# A428 Black Cat to Caxton Gibbet improvements

9.88 Schedule of Changes to the Environmental Masterplan

December 2021

Drawing Number: HE551495	ACM	ELS	P02
Location: GEN_SW_Z_ZZ	DR-LV	-0011

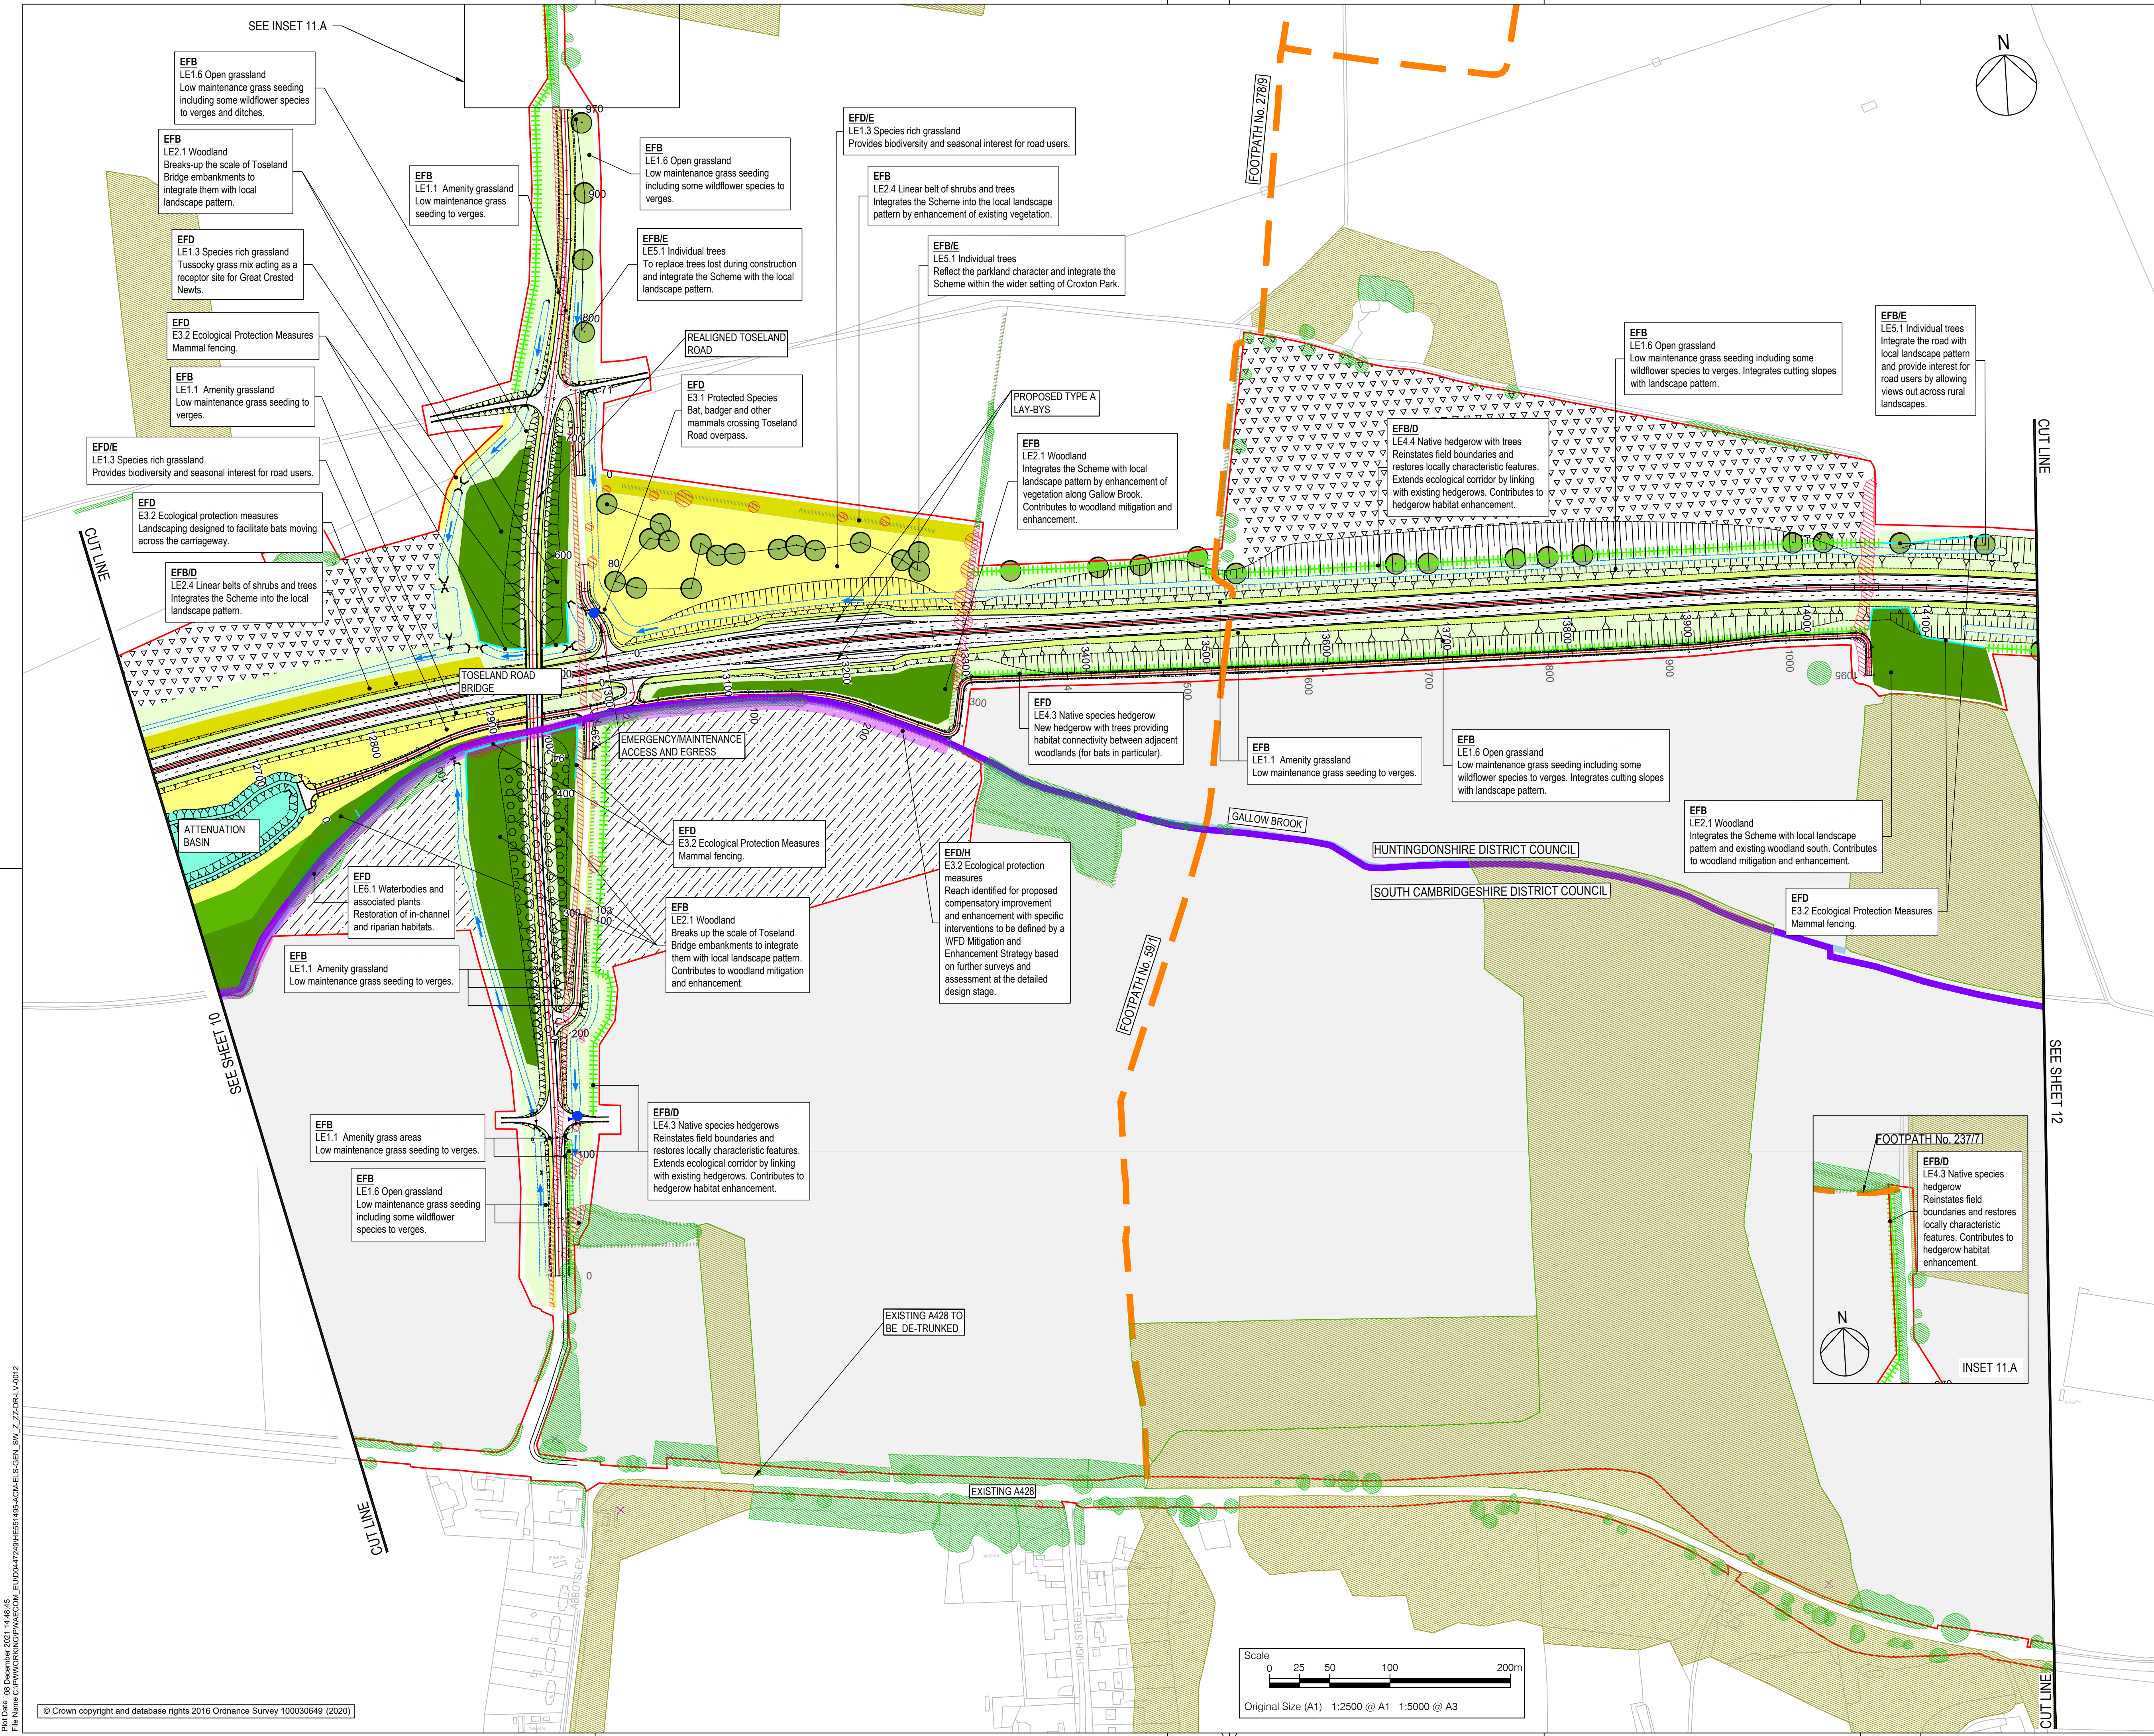
11	DR-LV-0011 between chainage 12300 – 12400	Natural England	GCN Mitigation Licence	LE1.3 Species rich grassland Tussocky grass mix as terrestrial habitat for Great Crested Newts added.	Deadline 6	Figure 2.4v3

Drawing Number HE551495 -ACM -ELS -	Location GEN_SW_Z_ZZ_DR-LV-0012	Rev P03
----------------------------------------	------------------------------------	------------

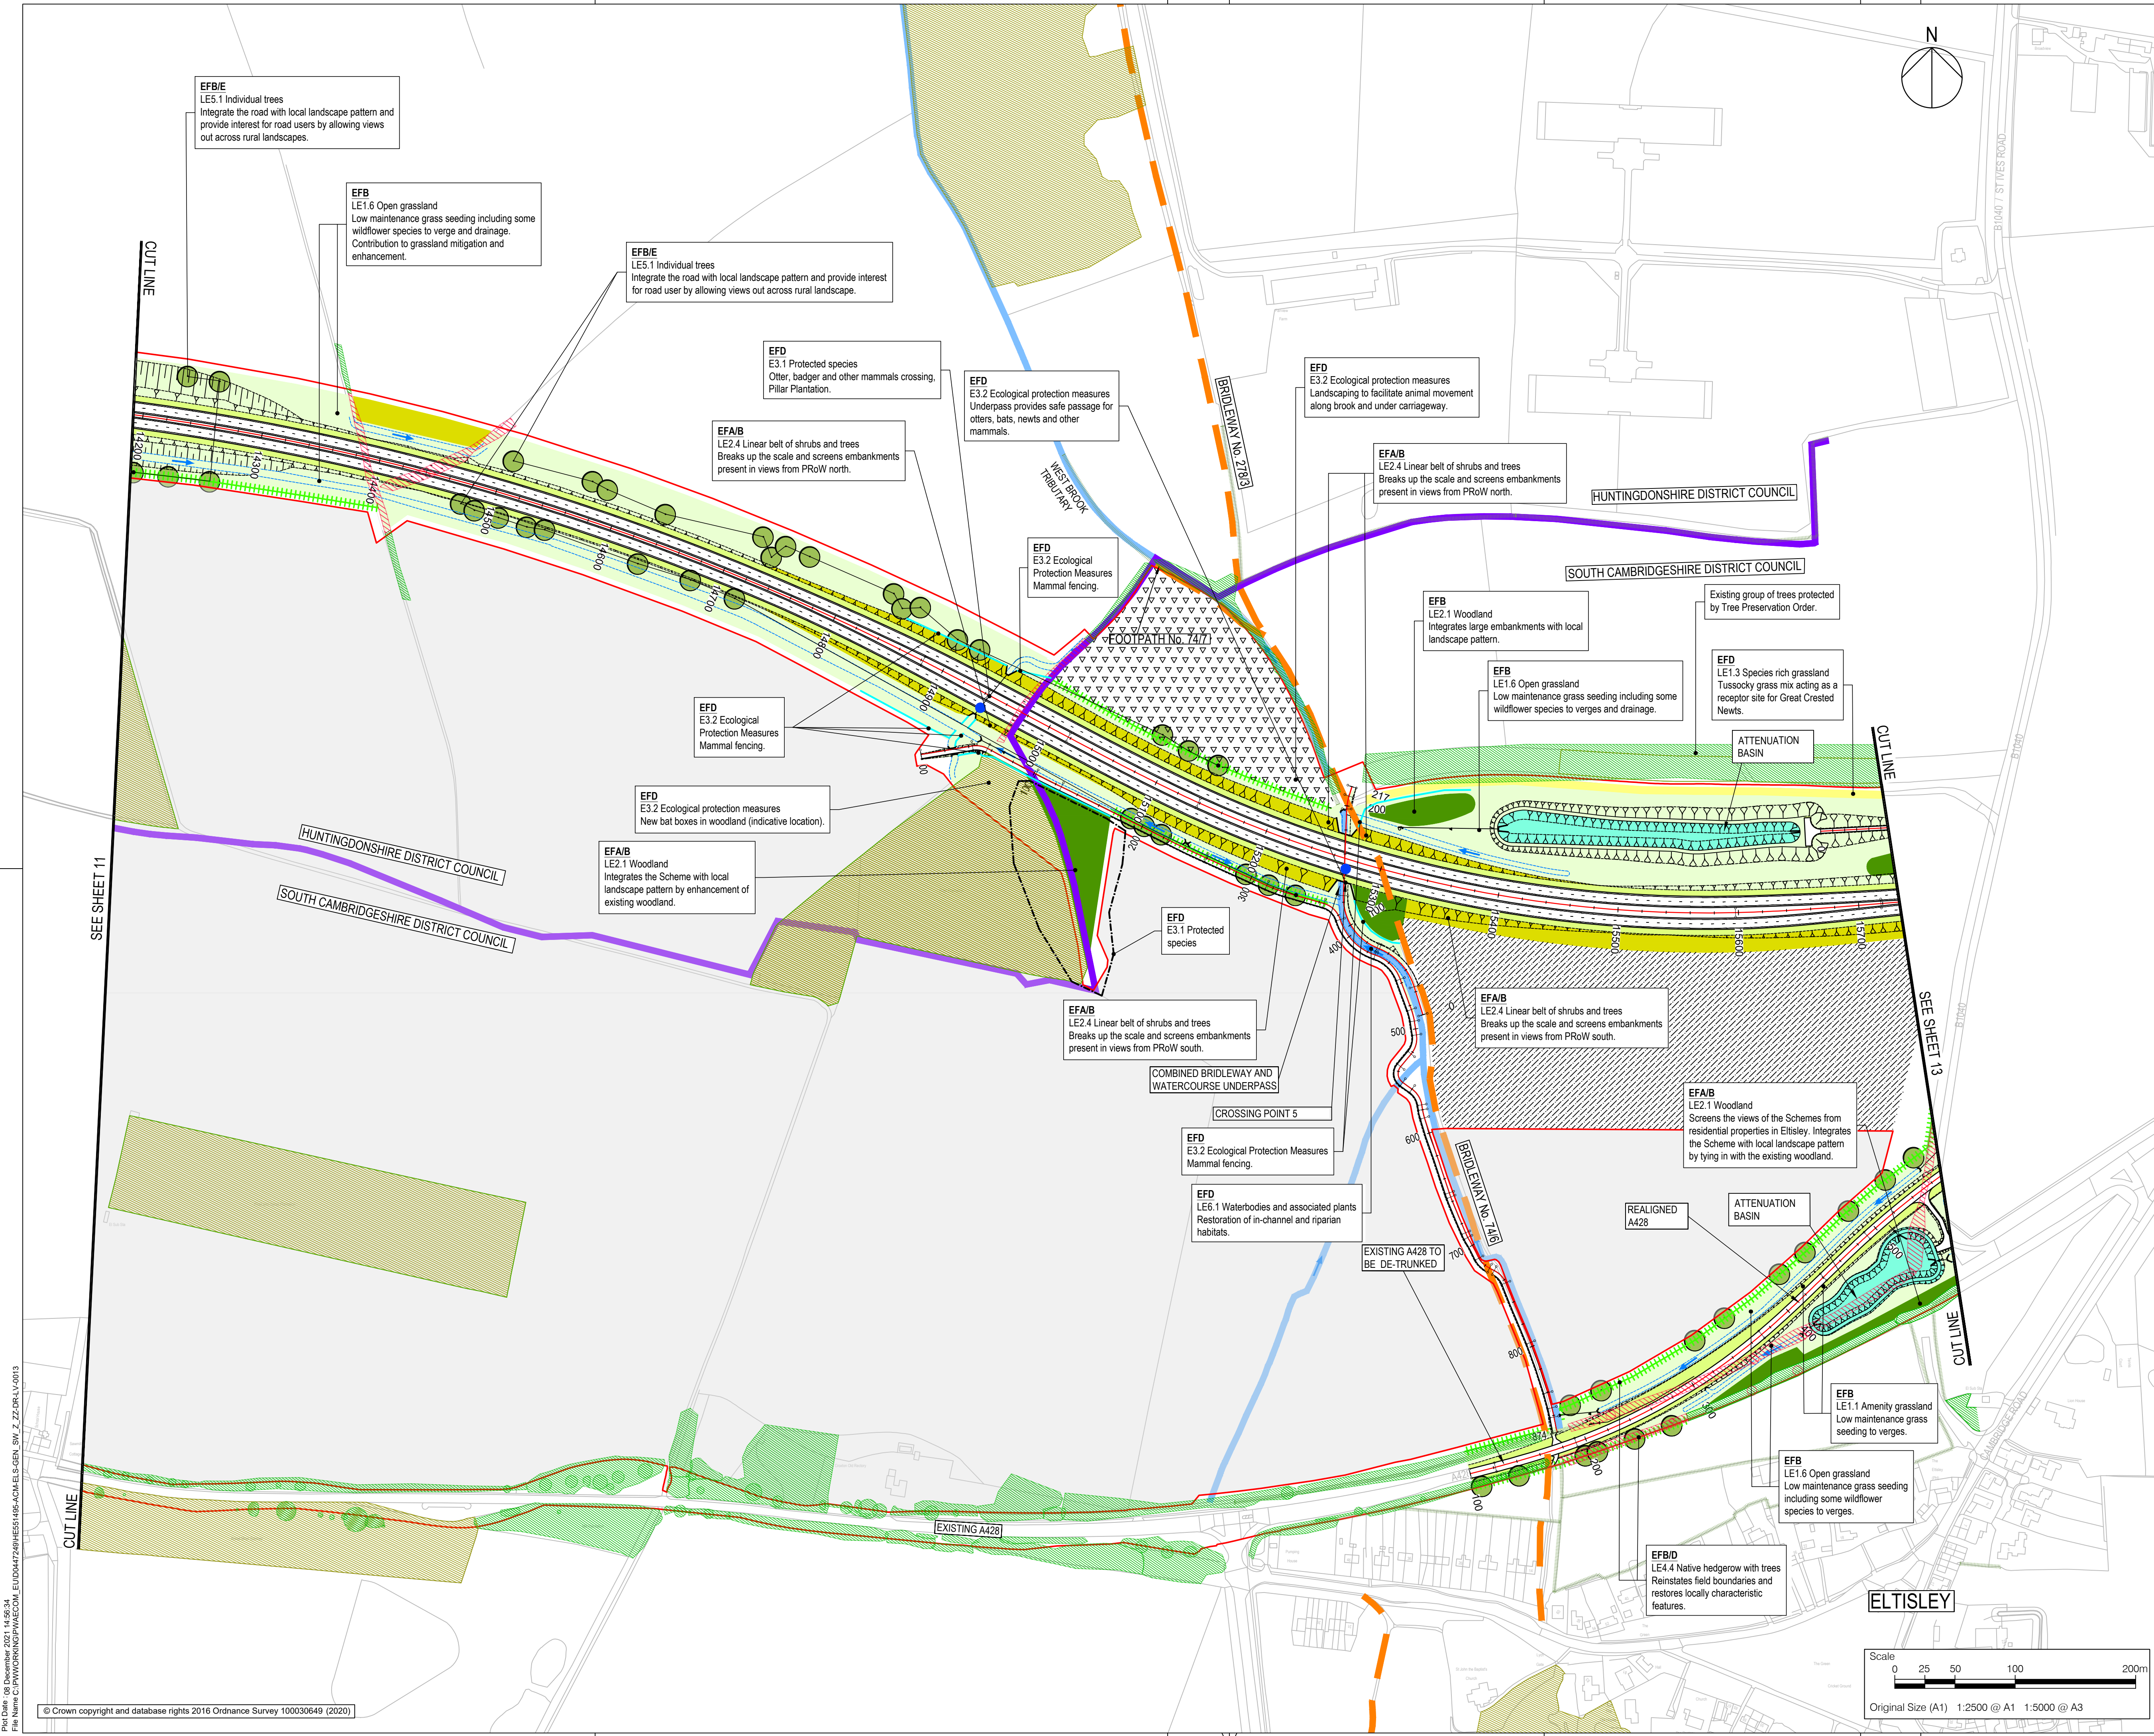
Ref	Environmental Masterplan page no Ref. with chainage	Consultee	Comments from consultee (Rationale for the change)	Change made	Deadline submitted	Environmental Masterplan Version
12	DR-LV-0012 between chainage 12800 – 12900	Natural England	GCN Mitigation Licence	LE1.3 Species rich grassland Tussocky grass mix as terrestrial habitat Great Crested Newts.	Deadline 6	Figure 2.4v3
13	DR-LV-0013 between chainage 15600 - 15700	Natural England	GCN Mitigation Licence	LE1.3 Species rich grassland Tussocky grass mix as terrestrial habitat for Great Crested Newts added.	Deadline 6	Figure 2.4v3
14	DR-LV-0015 between chainage 18200 – 18300	Natural England	GCN Mitigation Licence	LE6.1 Waterbodies and associated plants, pond proposed as receptor site for GCN.	Deadline 6	Figure 2.4v3
